Our Ref: 20/01099/HOU  
Your Ref: 58 Chelsea Road,  
Southsea - 4...

LOCATION: 58 Chelsea Road, Southsea, PO5 1NJ, ,

PROPOSAL: Construction of rear dormer **(20/01099/HOU)**

Drawing Title
**Loft Conversion
Plans & Elevations**

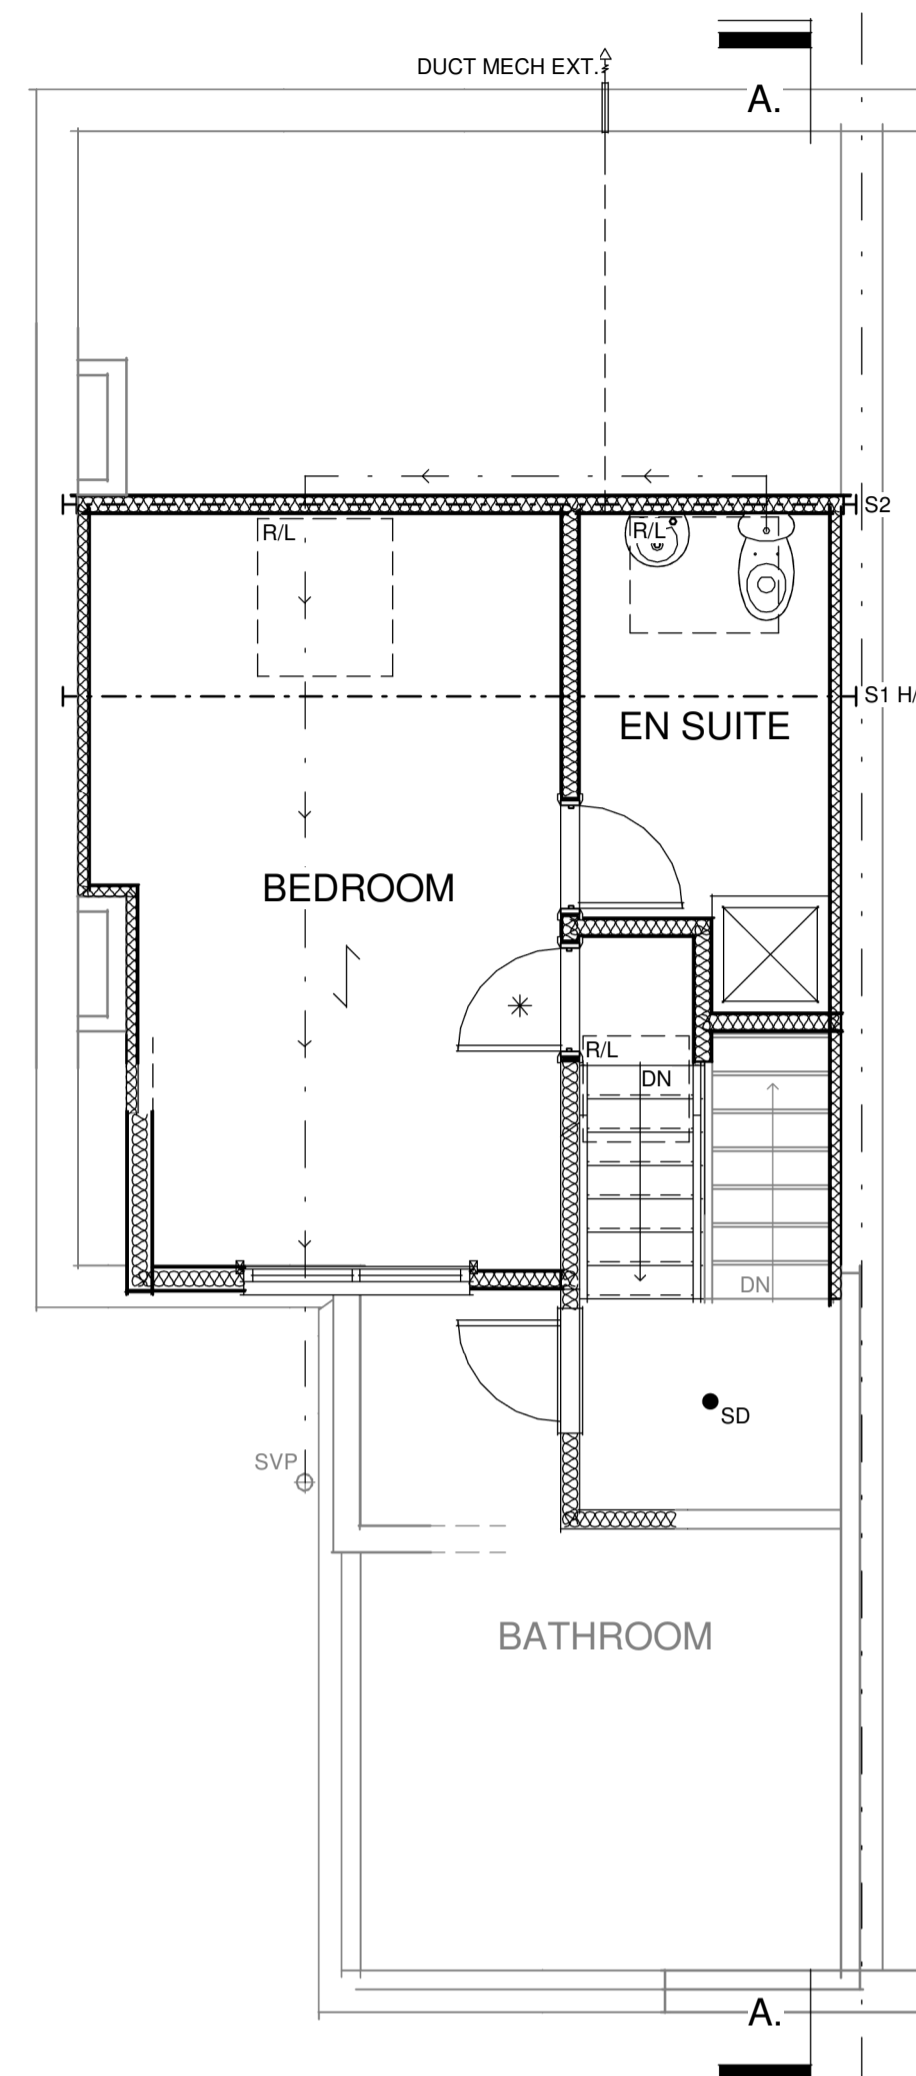
- 1) Please clarify if the loft conversion is being applied for under this application
- 2) Please provide the other side elevation for existing and proposed plans showing the proposal/alterations. Please submit this at a stated standard metric scale such as 1:50 or 1:100, with a scale bar or dimensions annotated to allow the confirmation of the scale
